Response to Submissions Report

Daroobalgie Solar Farm

21 November 2022

Figure 4 Proposed BESS layout

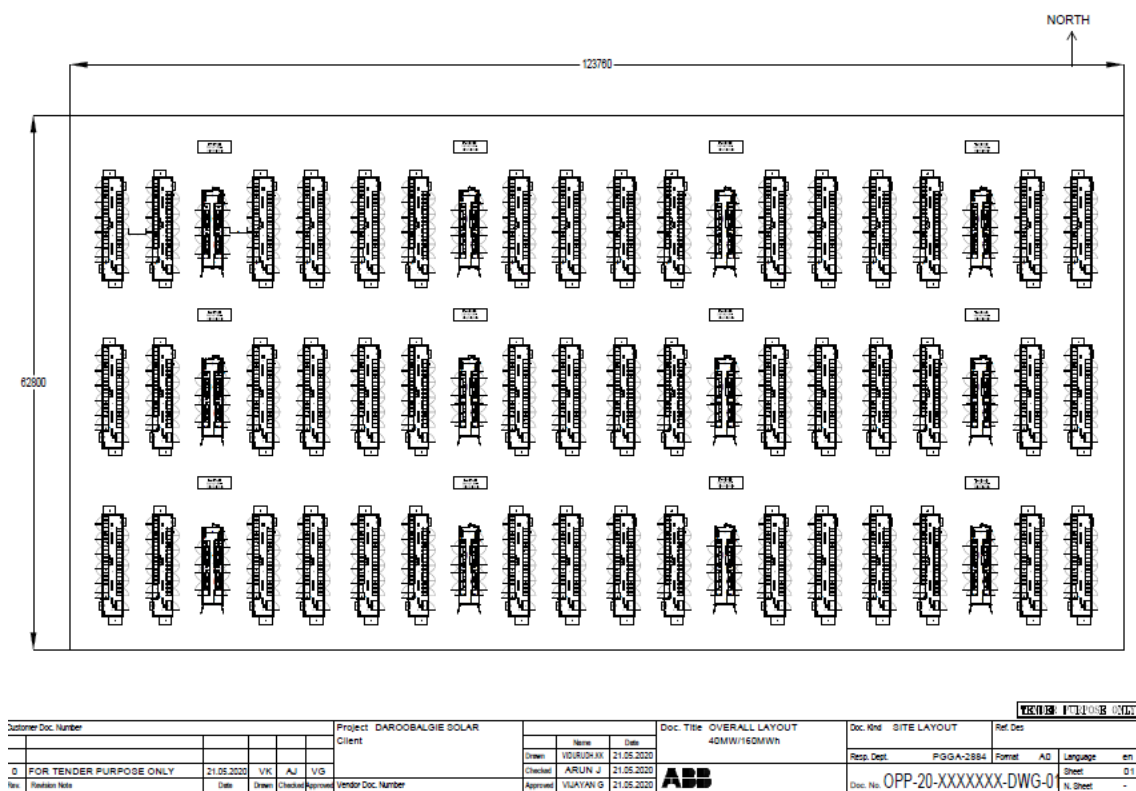
GIS Data	Provide all GIS data as required by table 24 of the BAM.	Provided
Department of Planning & Environment (DP&E)		
Hazard Analysis – BESS	<p>Provide further information in the Preliminary Hazard Analysis for the Department to verify the separation distances between battery sub-units (containers, enclosures etc) are sufficient to ensure a fire does not propagate between the individual sub-units including:</p> <ul style="list-style-type: none"> • Verification that the battery energy storage system (BESS) would be accommodated within the area designated for the BESS, accounting for separation between BESS sub-units to prevent fire propagation. This verification should examine relevant codes and standards for BESSs (such as NFPA 855, AS 5139, IEC 62897, UL 9540, FM Global DS 5-33) and the findings of the 2021 Victorian Big Battery fire; and 	<p>The project layout of the facility at this early stage of design, has the BESS located outdoors with 2 metres between open doors of individual BESS units and 2 metres between open doors of BESS units and transformer units (where relevant). The BESS is approximately 25 metres from the closest site boundary and 100 metres from administration/ maintenance buildings. Proposed BESS layout below.</p>

Issue	Detail of Issue/Recommendation	Response																																																		
	<ul style="list-style-type: none">demonstrating that the fire risks from the BESS can comply with the Department’s Hazardous Industry Advisory Paper No. 4, ‘Risk Criteria for Land Use Safety Planning’.	<div></div> <div>

</div> <p>The most relevant guidance for BESS separation distances comes for United States of America. The proposed layout aligns with guidance on separation distances as set out by the most recently released codes. The 2021 Victorian Big Battery fire is also less relevant given the proposed layout of the BESS associated with the project, however, does highlight the importance of having a functioning battery monitoring system throughout all life-cycle periods (including commissioning). Additionally, the findings from the Victorian Big Battery fire indicate that appropriate thermal testing is needed when determining final BESS layout.</p> <ul style="list-style-type: none">NFPA 855 – 1 m to adjacent ESS units and adjacent walls, 3 m from buildings, roads, boundary, hazardous or combustible materials and 3 m clearance of combustible vegetationAS 5139 – 0.6 m between equipment. Deemed less relevant because standard focus is on battery system and all other equipment within a battery system room, not specifically between units.IEX 62897 – under development	Customer Doc Number		Project: DARROOBALGIE SOLAR		Doc Title: OVERALL LAYOUT		Doc Ref: SITE LAYOUT		Ref Des				Client		40000/100000		Rev: 01				Date: 21.05.2022		Drawn: YORIKO/11		Date: 21.05.2022		Rev: 01		Format: A3		By: FOR TENDER PURPOSE ONLY		Checked: ARUN J		Date: 21.05.2022		Rev: 01		Language: en		Rev: 01		Date: 21.05.2022		Rev: 01		Date: 21.05.2022		Rev: 01	
Customer Doc Number		Project: DARROOBALGIE SOLAR		Doc Title: OVERALL LAYOUT		Doc Ref: SITE LAYOUT		Ref Des																																												
		Client		40000/100000		Rev: 01																																														
Date: 21.05.2022		Drawn: YORIKO/11		Date: 21.05.2022		Rev: 01		Format: A3																																												
By: FOR TENDER PURPOSE ONLY		Checked: ARUN J		Date: 21.05.2022		Rev: 01		Language: en																																												
Rev: 01		Date: 21.05.2022		Rev: 01		Date: 21.05.2022		Rev: 01

Issue	Detail of Issue/Recommendation	Response
		<ul style="list-style-type: none"> UL 9540 – 1 m to adjacent ESS units and adjacent walls; reduced distances require a large-scale fire test via valid thermal testing process – UL 9540a: Test Method for Evaluating Thermal Runaway Fire Propagation in BESS - invalid with high winds (VBB findings 2022) FM Global DS 5-33 – 6 m between ESS units (or provide a thermal barrier rated a minimum 1-hour) & 2.7 m from combustible elements. Noting that this is not as recently reviewed compared to other standards. VBB Findings – VBB units had spacing of 0.15 m to sides and back of each unit with 2.4 m in front of each unit (UL 9540A). Fire escalation due to environmental conditions (high winds) not being considered in UL 9540A & weakness in thermal roof design. Additionally, during commissioning several monitoring and protection systems were switched to off-line service mode, which allowed the initial fault to go undetected and resulted in the total loss of two battery units <ul style="list-style-type: none"> - Learnings: fire escalated between units separated by 0.15 m. Highlights the importance of a functioning battery monitoring system. <p>The risk of fire from BESS has been assessed in section 7.6 of the Hazard and Risk assessment report. There are no expected offsite impacts given the proposed location, and as such the risk of injury, fatality or property damage is negligible and complies with HIPAP 4. The onsite fatality risk also complies with HIPAP 4.</p>
